Engineers Comments Regarding Surface Water Drainage

Application Reference:	WA/33/26/PL	Reviewer Reference:	ADC/EXT5/AF
Planning Officer:	Hebe Smith	Date of Review:	04/06/2026
Site Name:	The Greenway, West Walberton Lane, BN18 0QS		
Application Description:	Construction of a self-build/custom build single dwelling, with garage outbuilding and associated works.		
Assessment Number:	1

Land north of The Green Way
Appendix 6 - tree protection plan

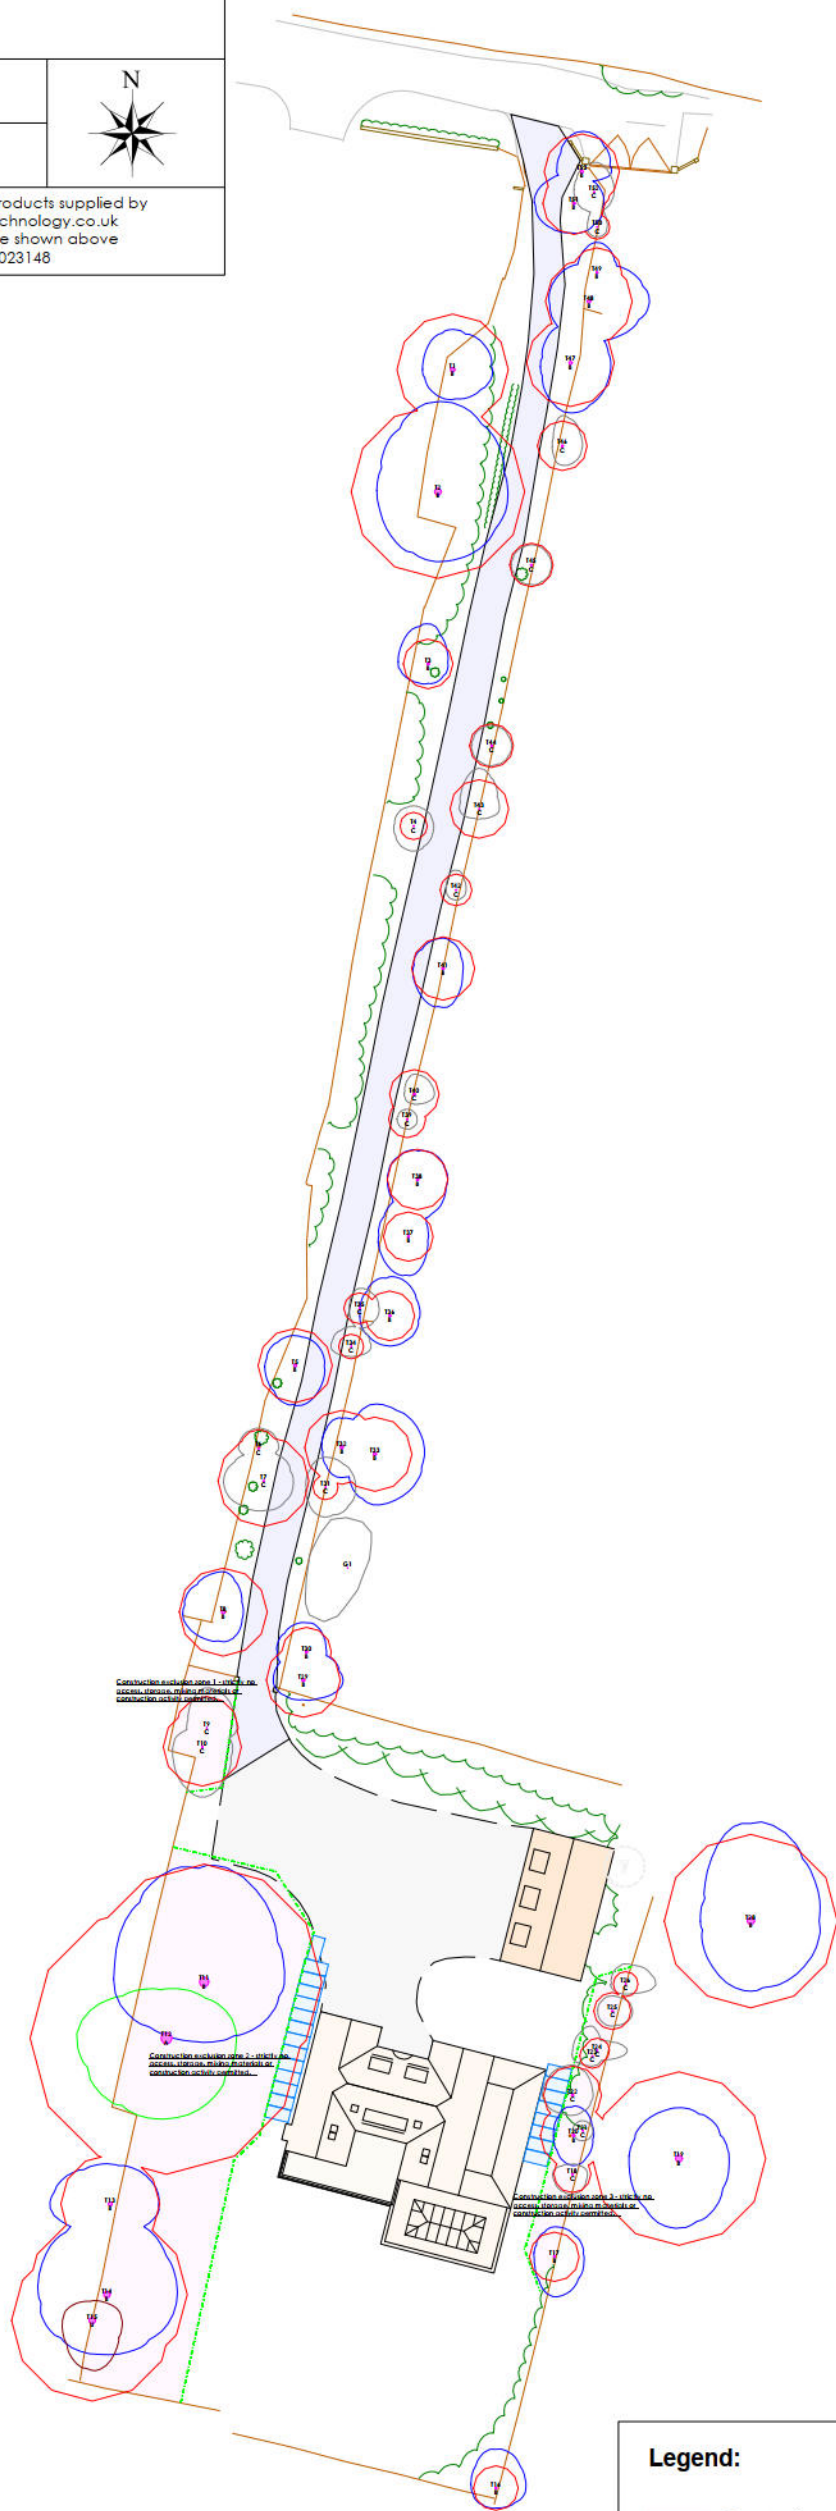
- 0.4. The existing trees on the eastern side of the access drive have root protection areas that conflict with the proposed permeable paving. It is also noted that root protection measures may significantly encroach within the root protection areas of some trees along the eastern boundary of the site. The Planning Officer may wish to consult the Arboriculture Officer for their views on this matter.

- 3.5. Please provide clarification as to how the permeable driveway with existing trees is designed and included in the drainage calculations in terms of how the storm water will be stored whilst retaining root protection areas which typically require 'no dig' construction.
- 3.6. The design does not currently meet the requirements of Standard 3 of the NSfS, therefore we **Object** to the application. The objection may be able to be removed once further information is reviewed.

- 7.1. An outline maintenance plan is provided which is proportionate to the scale and nature of development as the dwelling will be in a single ownership.
- 7.2. There are a significant number of good quality trees on the site, most of which are to be retained. These existing trees are a constraint to the drainage strategy as any drainage installations should not damage the trees, and the drainage infrastructure itself needs to be protected from tree root damage. The design as submitted demonstrates areas of conflict with the existing trees and their current root protection areas which will require root protection construction methods.
